From: Michael Eastham <Michael.Eastham@arun.gov.uk>
Sent: 03 June 2020 18:10
To: Planning.Responses <Planning.Responses@arun.gov.uk>
Subject: LU/90/20/DOC - PARCELS A2 & B6, Littlehampton - Drainage Drawings

Please upload onto Ocella the email below which is the revised consultation response from **ADC Drainage Engineers** to discharge of condition application **LU/90/20/DOC**.

Subject: RE: 2020-05-15-19163-PARCELS A2 & B6, Littlehampton - Drainage Drawings

From: Clark, Robert [REDACTED]
Sent: 15 May 2020 10:27
To: Michael Eastham <Michael.Eastham@arun.gov.uk>; Paul Cann <Paul.Cann@arun.gov.uk>
Subject: 2020-05-15-19163-PARCELS A2 & B6, Littlehampton - Drainage Drawings

Scale	A1 @ NTS	Drawn	TB
Date	May 2020	Checked	JB
File	19163 / dwgs / civils / current	Drawing	19163 / 311

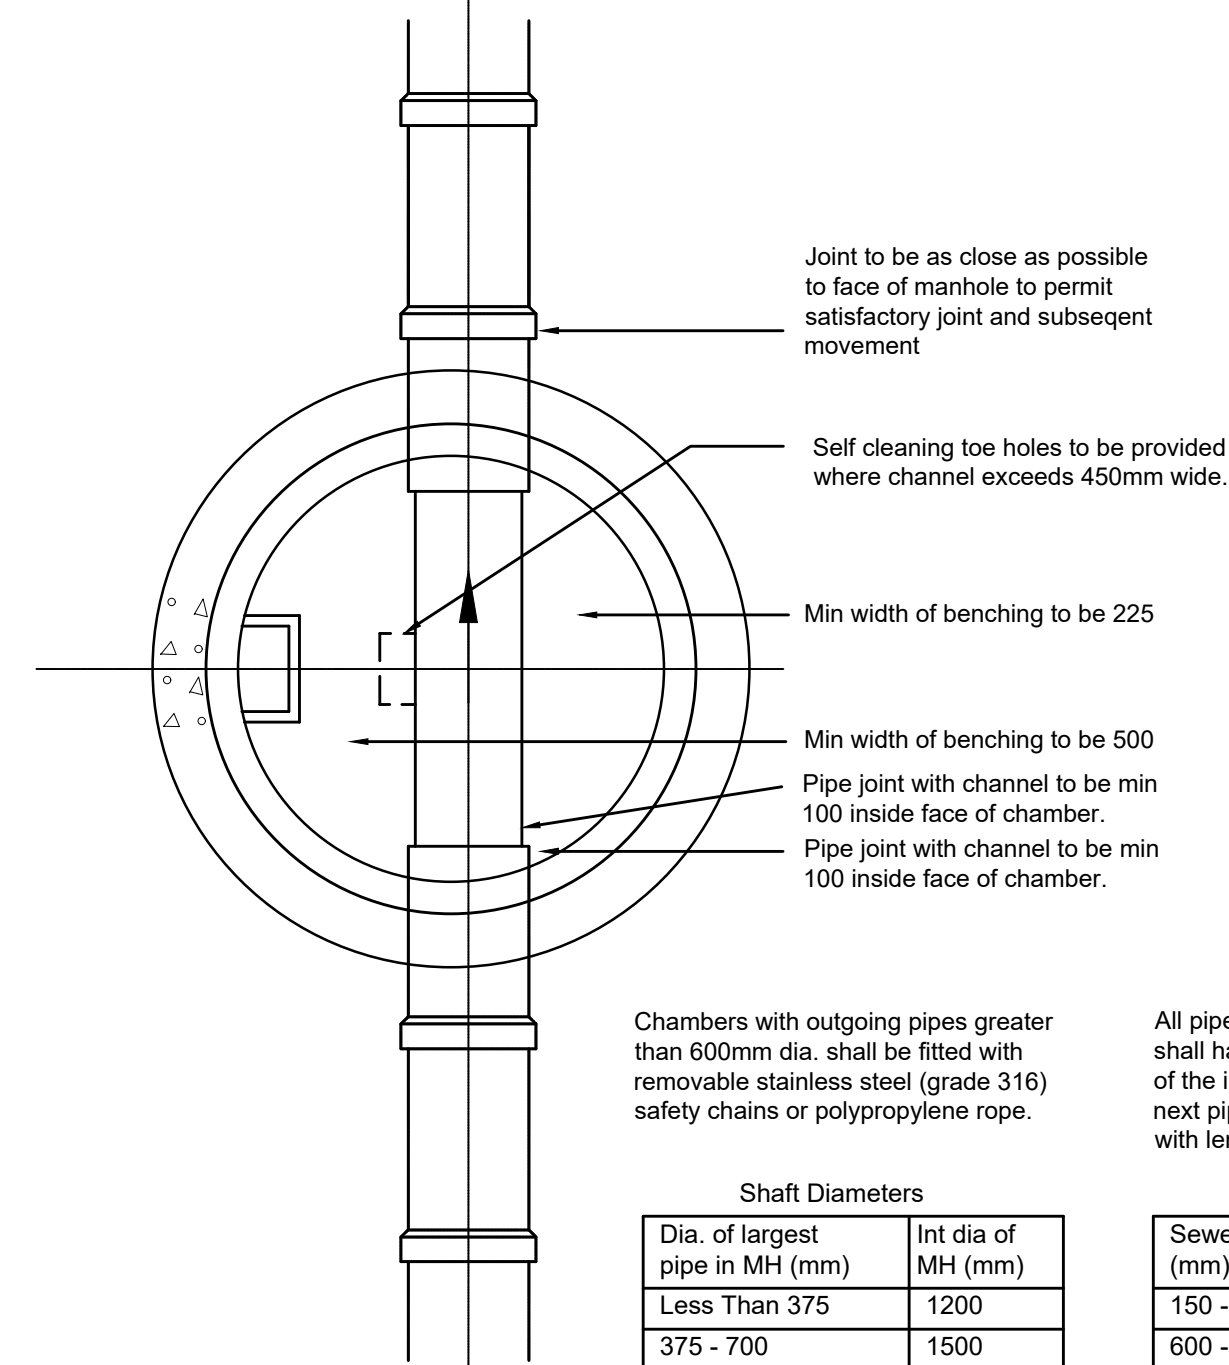
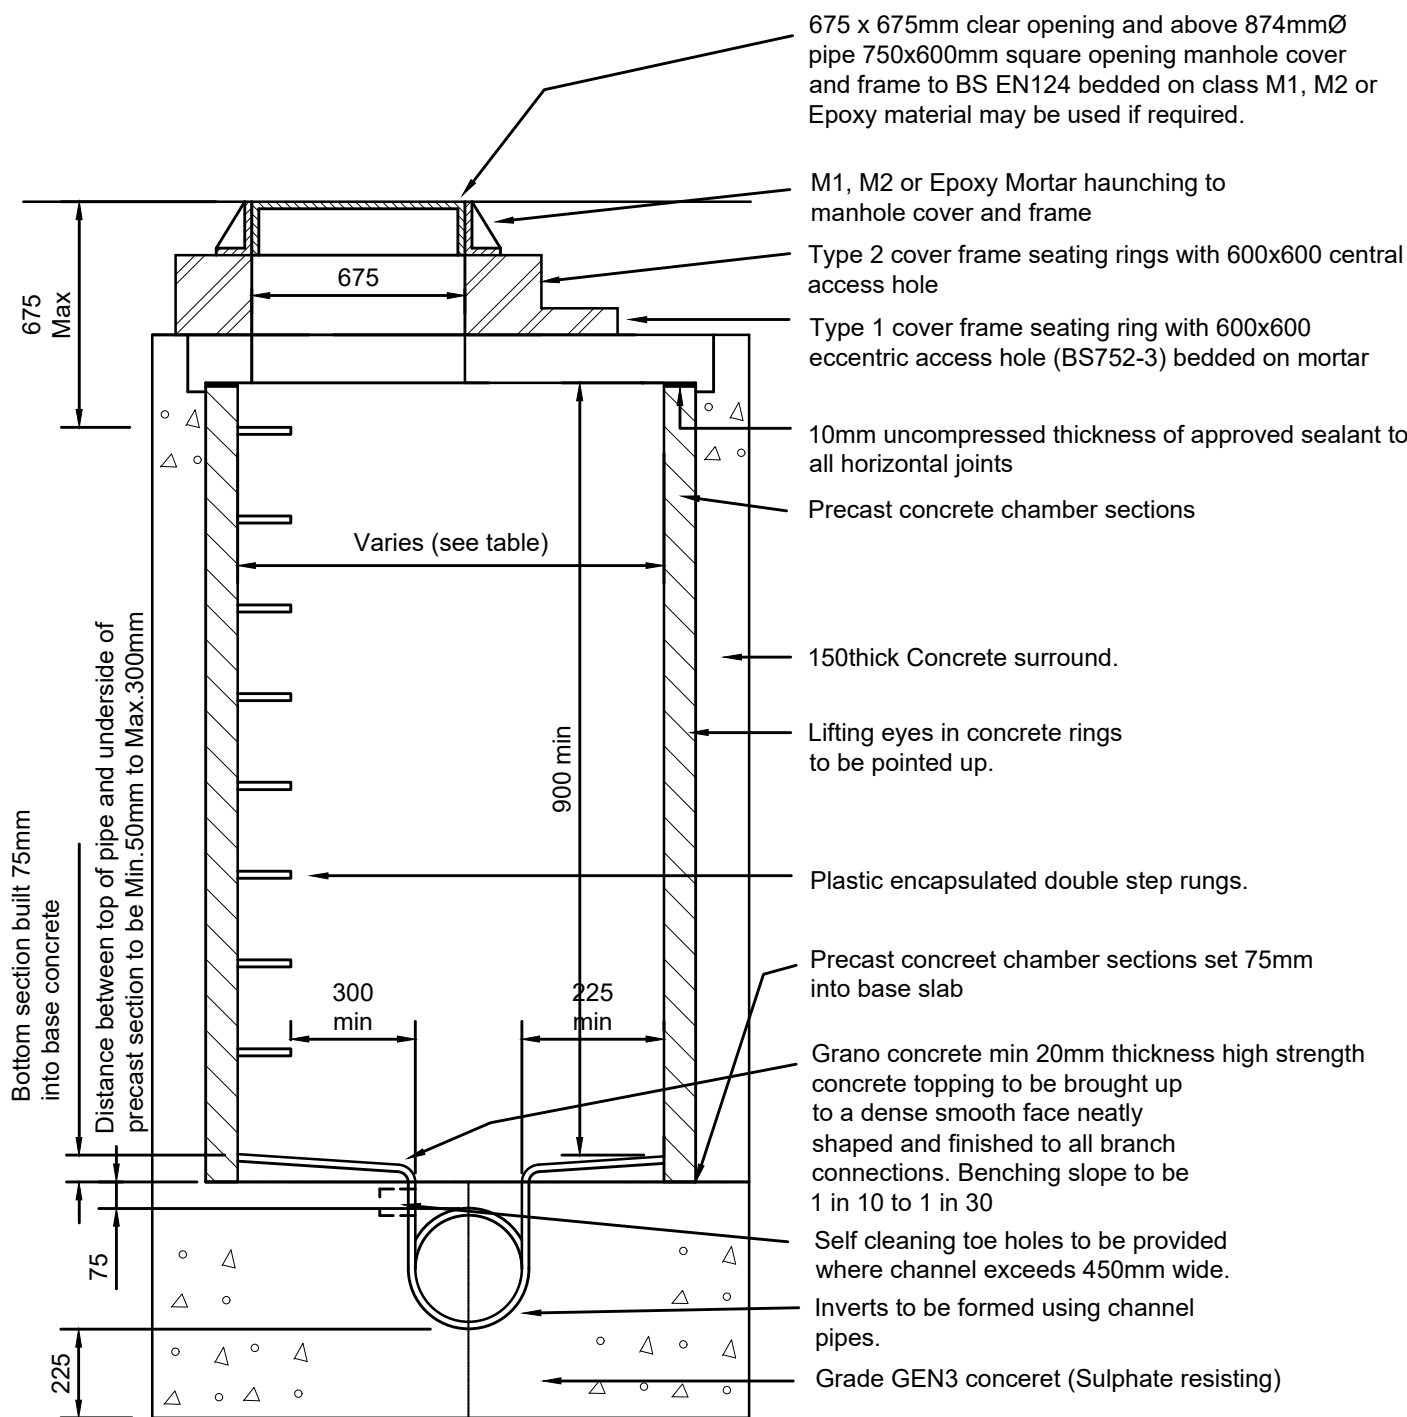
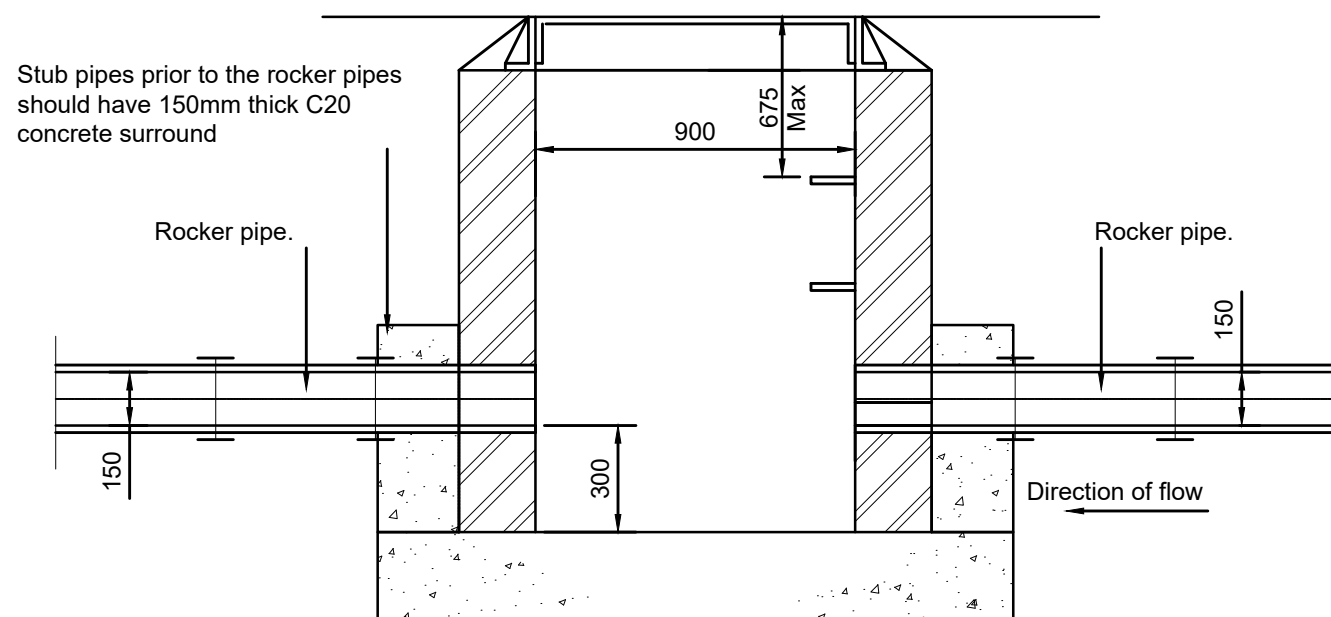
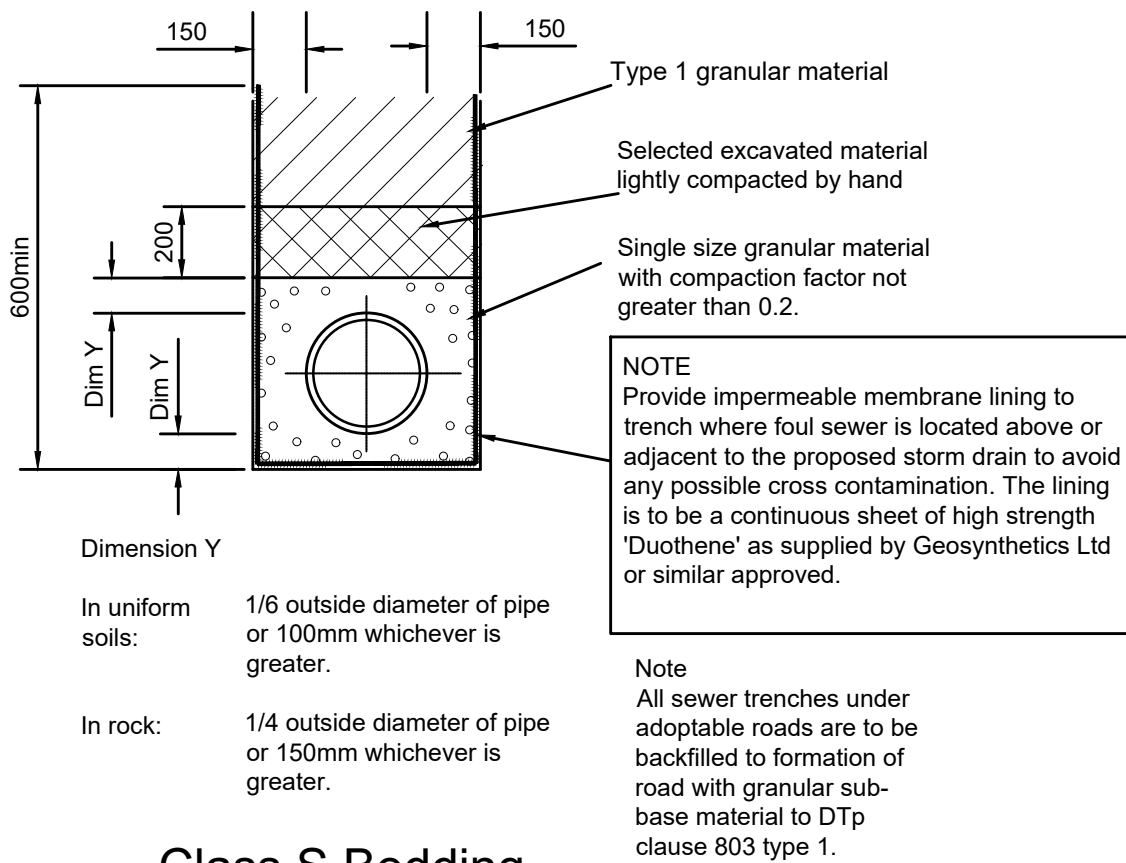
1. CP1 and CP2 (catchpits) on the manhole schedule drawing need to refer to a catchpit detail, not a type B manhole. *ok*
2. Provide non adoptable manhole construction details. *ok*
